Recommendation Report for Planning Permission for Works or Extension to a Dwelling

REF NO: M/98/25/HH

LOCATION: 1 Elmer Court
Elmer
Middleton-on-sea
PO22 6JT

PROPOSAL: Extension and alterations to form a rear facing balcony and sliding doors (part retrospective).

04 REAR (SOUTH) ELEVATION:

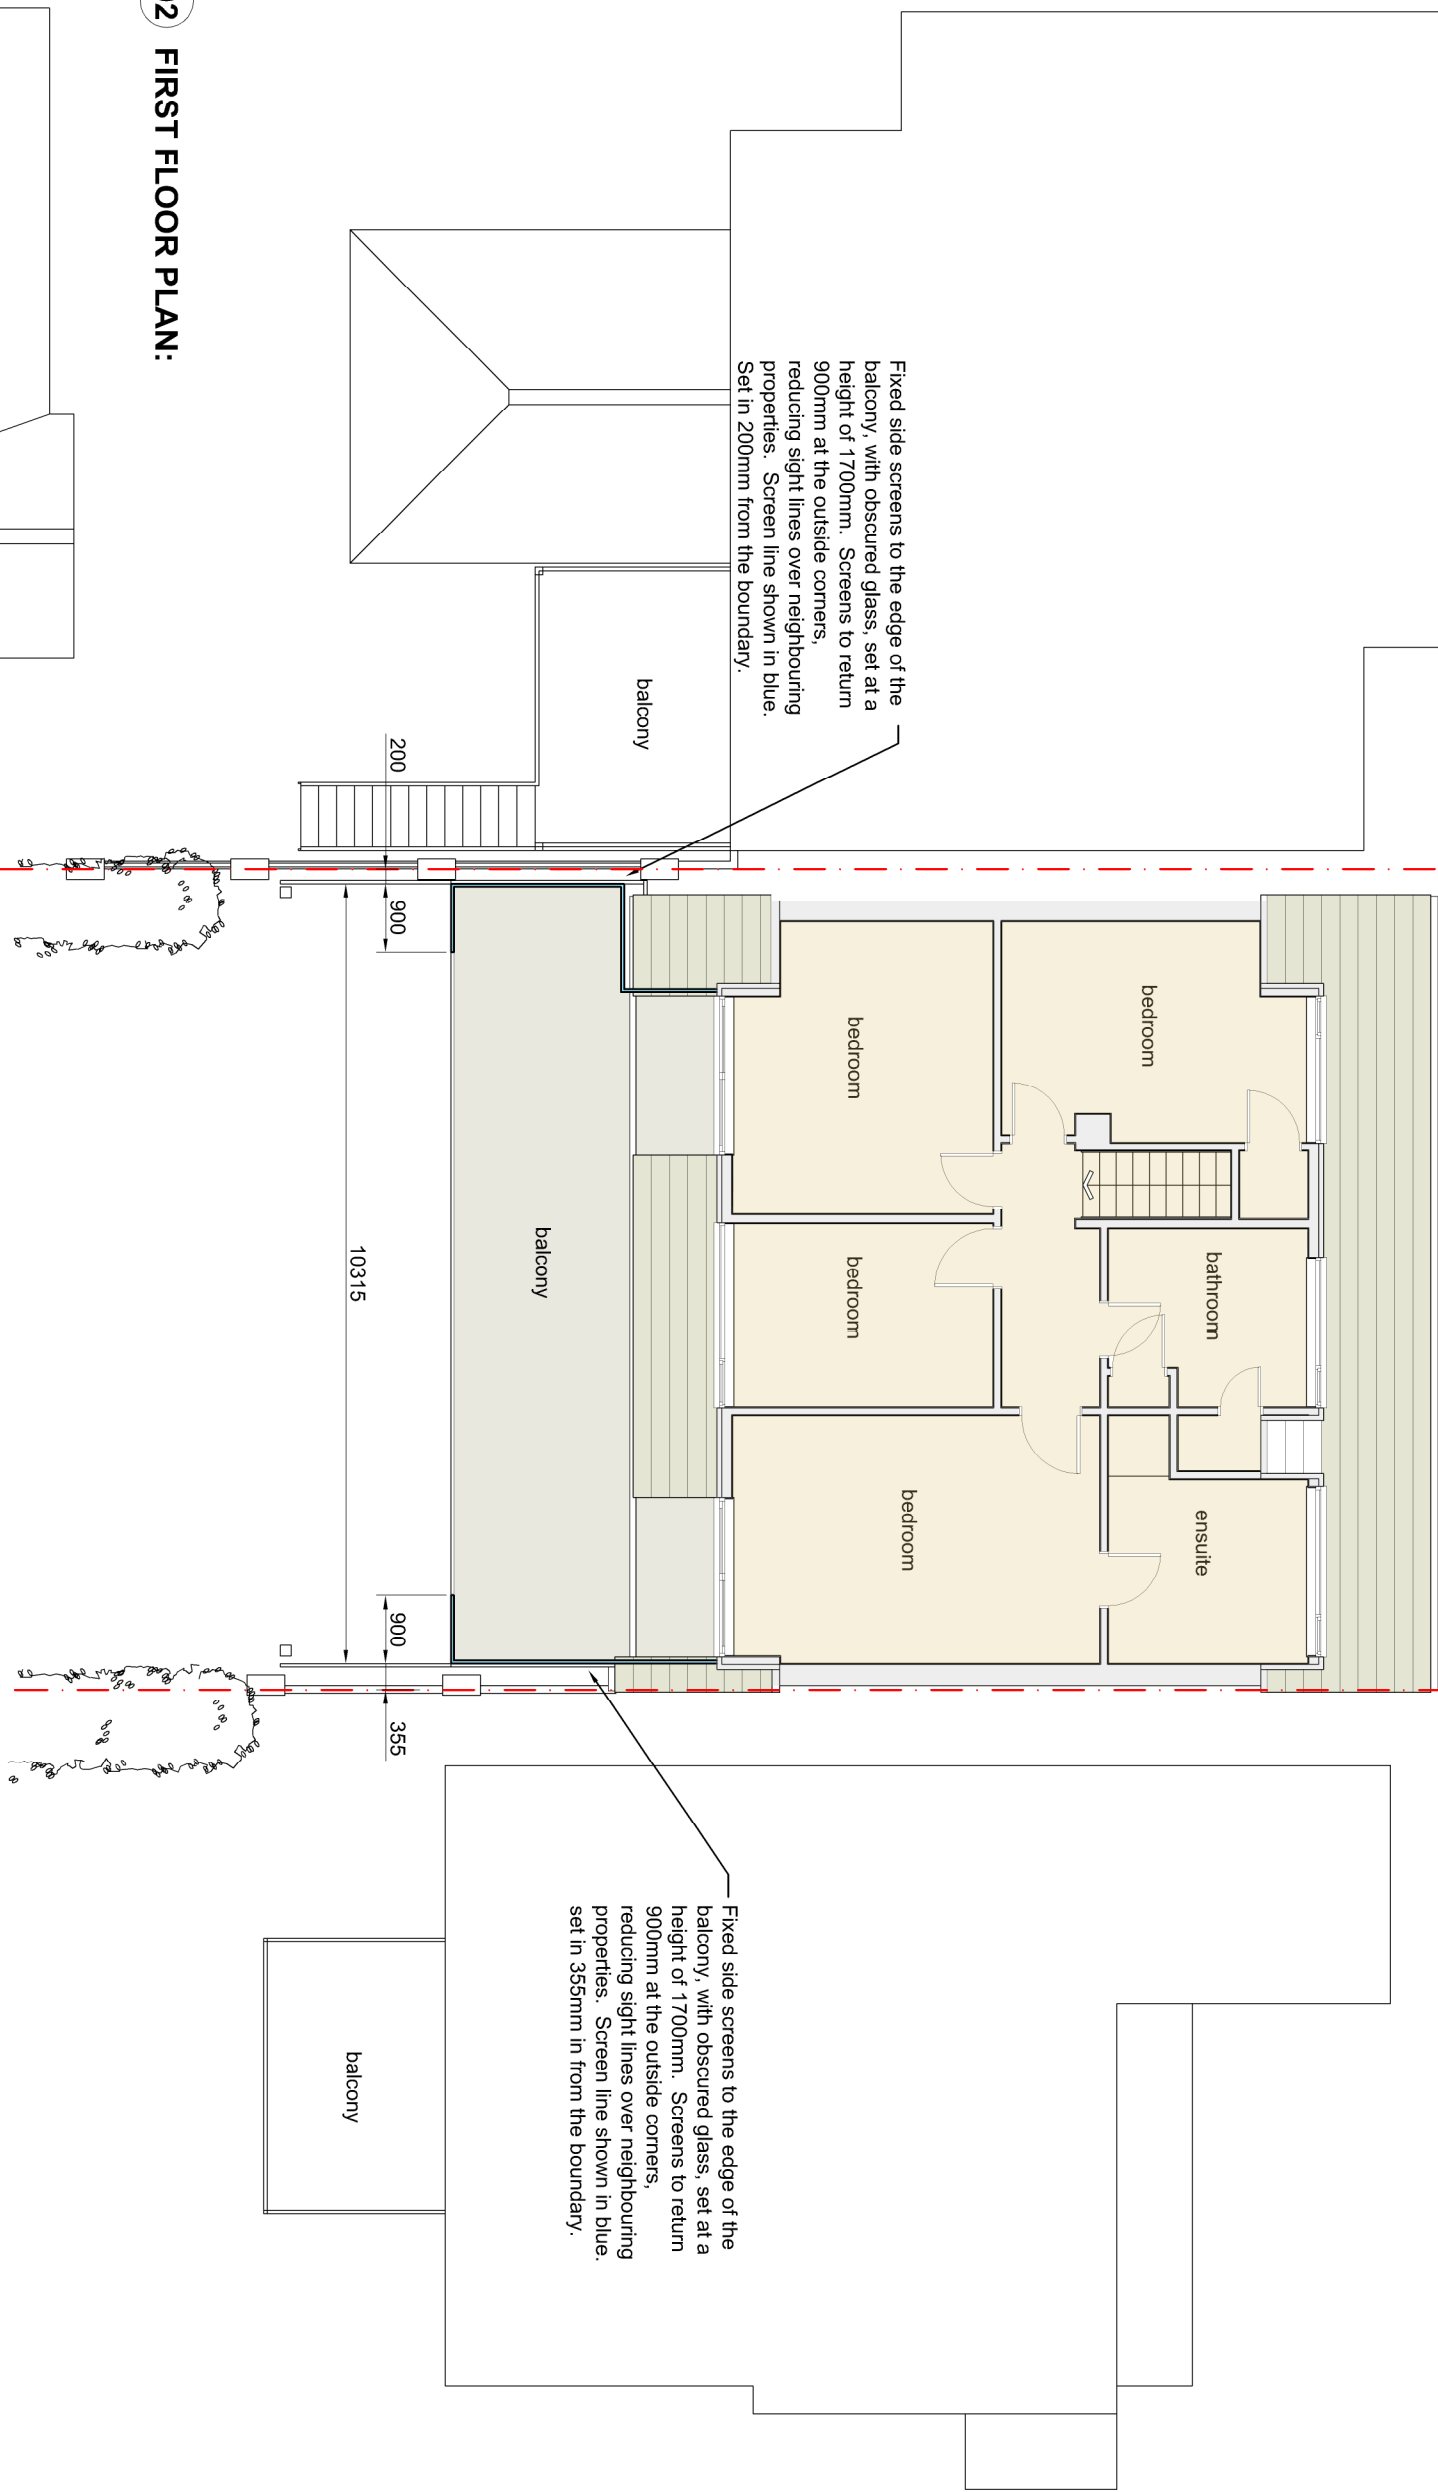
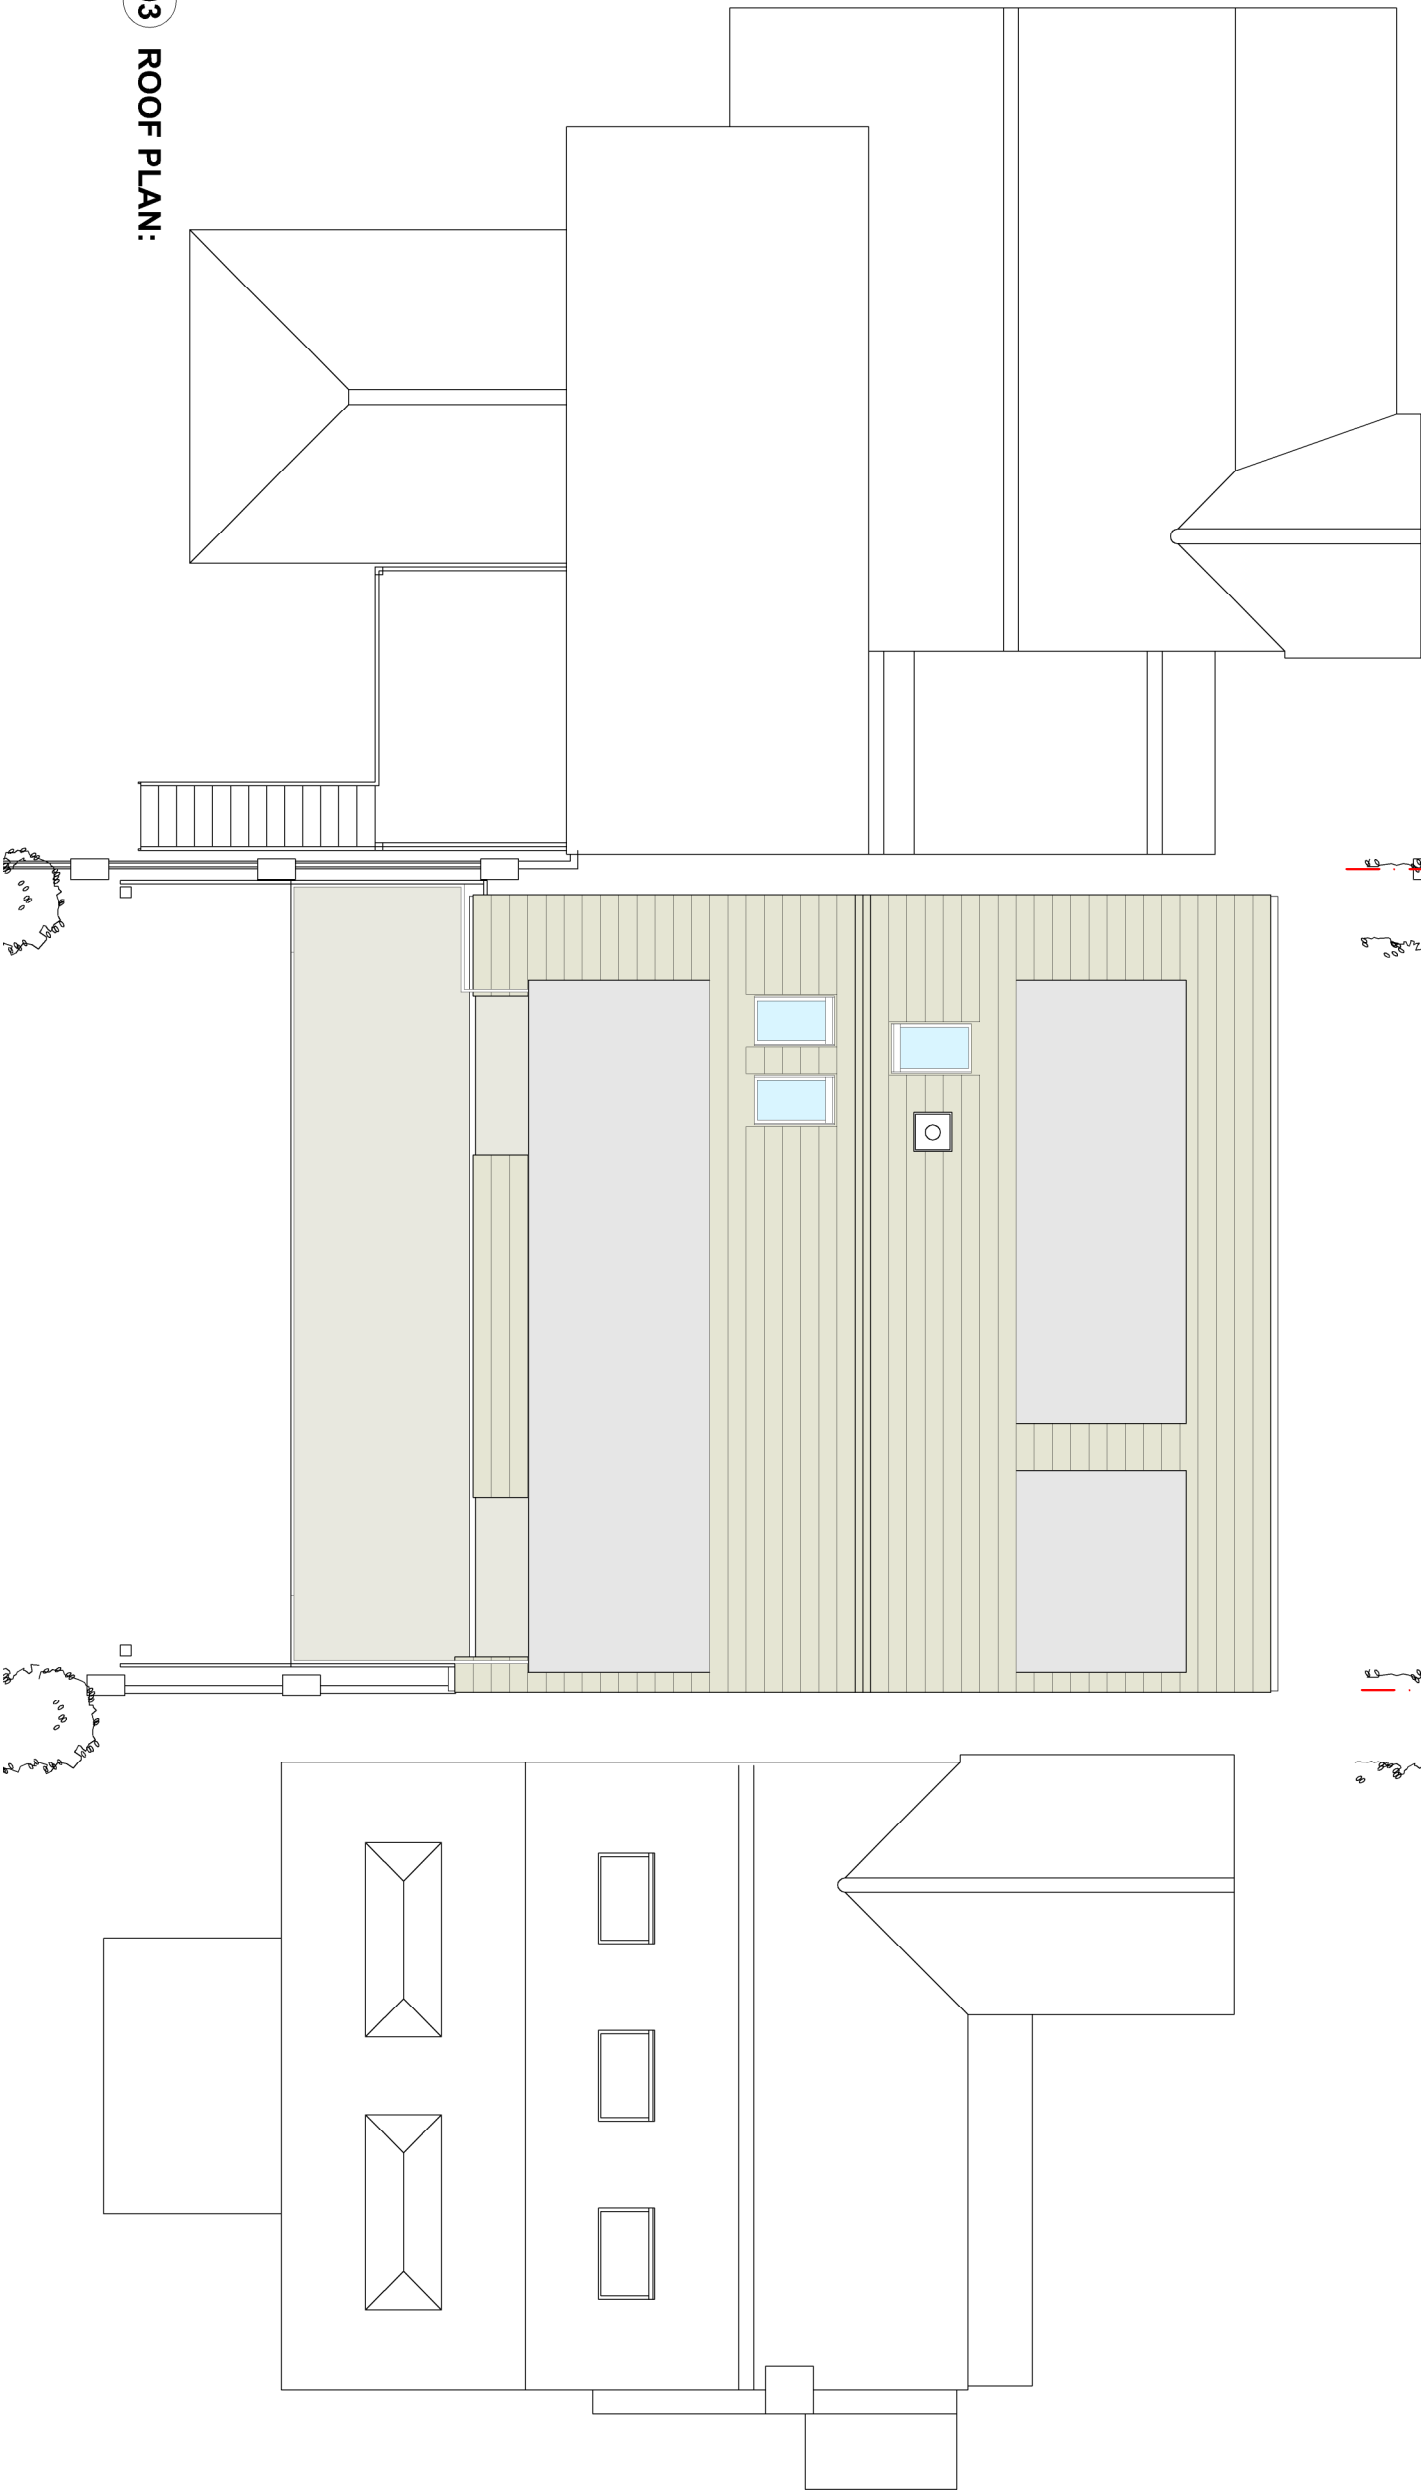
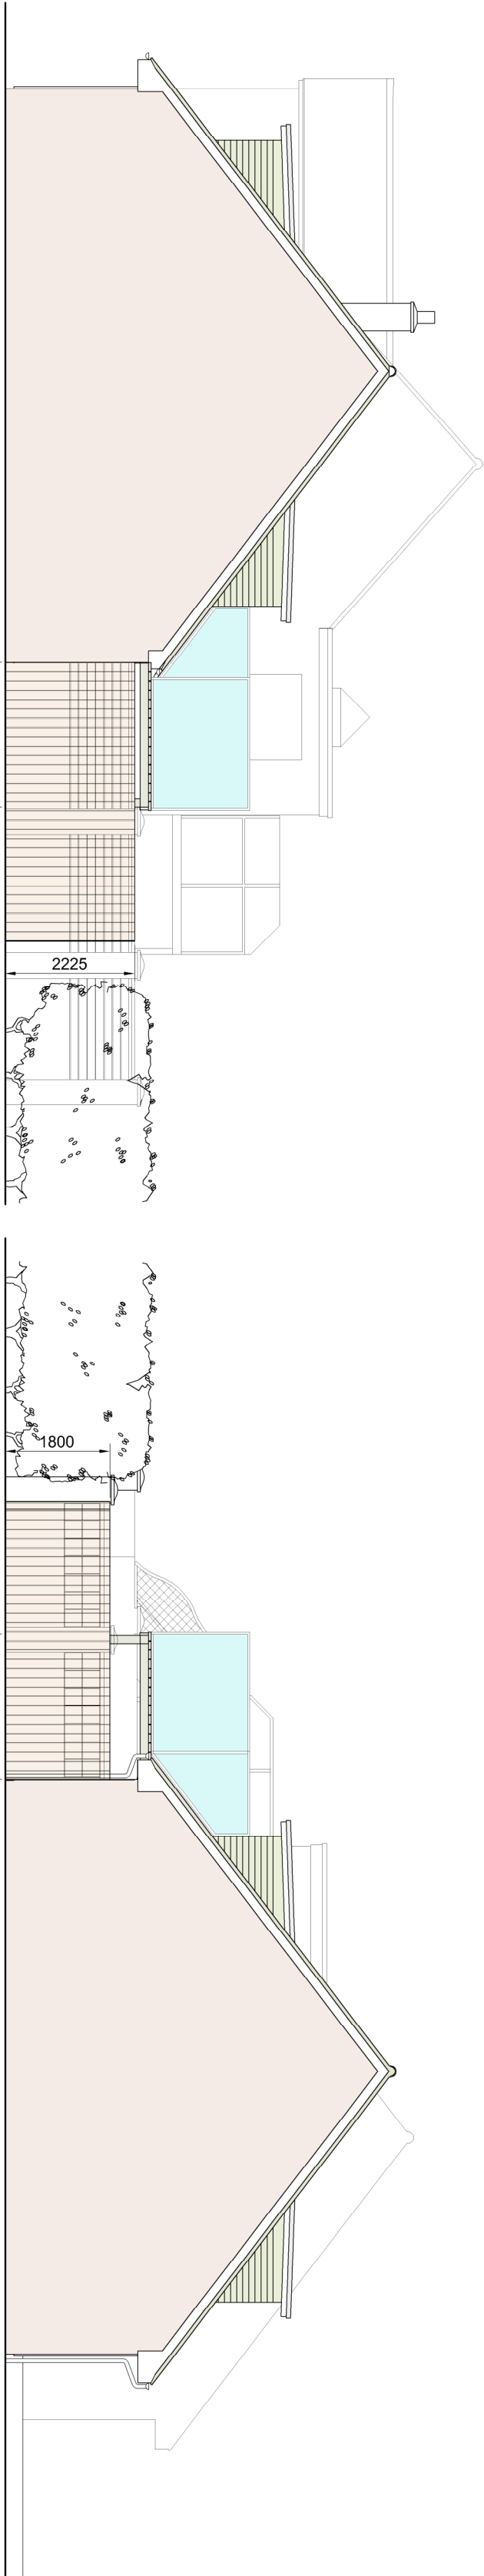
Regarding inaccurate plans, clarification has been sought from the planning agent and matters resolved through clarification that the resultant minimal reduction in width is due to the removal of the timber uprights.

The proposed balcony would measure 10.3m in width and 3.4m in depth. Fixed obscurely glazed side screens would be constructed to the eastern and western sides of the balcony, measuring 1.7m high and would return 0.9m in the south east and south west corners. The balcony would be facilitated by the reduction in depth of the existing pergola style canopy extension to the rear, which would extend no further than the proposed balcony. The single storey structure would be constructed from timber, with a metal and glass balustrade surrounding the balcony. The use of glass balustrades would minimize the visual impact of the proposal, particularly compared to the previously refused timber side panels. Furthermore, it is noted that the proposed screening and balustrading would be similar to that surrounding the balconies of immediate neighbouring properties. While it is noted that the proposed balcony is wider than its adjacent neighbours, there are a number of similar examples along this stretch of coastline within Elmer. As identified by the Planning Inspector in dismissing the appeal (reference APP/C3810/D/25/3362664) following the previously refused scheme (M/100/24/HH), balconies form a prominent and established feature of this area, and the introduction of this balcony would not appear out of place within its surroundings.

The proposed single storey structure and balcony would be set in 0.2m from the western side boundary and would project 1.1m further in depth than the neighbour's balcony on that side. There is also an external staircase serving the neighbouring balcony, located close to the shared boundary with the application site which it would not extend beyond. To the east side, the proposal would be set in 0.3m and would extend directly in line with the existing rear wall of this neighbour, with the neighbouring balcony extending 2.4m further in depth. The proposed balcony would result in some increased overlooking and an increase in the perception of overlooking of the rear gardens of the property's neighbours to the east and west. To mitigate this, the eastern and western sides of the balcony and 0.9m across the rear elevation of the balcony from the corners, are proposed to be screened with obscurely glazed panels with a height of 1.7m, and a condition is attached to this planning permission to ensure the screening is installed prior to first use of the balcony and retained in perpetuity to prevent excessive and harmful overlooking of the rears of the neighbouring properties to the east and west. Therefore, the balcony does not unacceptably compromise the privacy of neighbouring dwellings.

It is noted that the neighbouring property, No.2 Elmer Close, has a first-floor side window that directly faces the application site, however this window is obscurely glazed. Due to this treatment, it would not experience any adverse impact on privacy as a result of the proposal.

- 3 Prior to the first use of the balcony hereby permitted, fully obscured screening to a height of 1.7m shall be installed along the eastern and western sides of the balcony, and the south eastern and south western returns along the rear of the balcony. This arrangement shall be permanently retained thereafter.
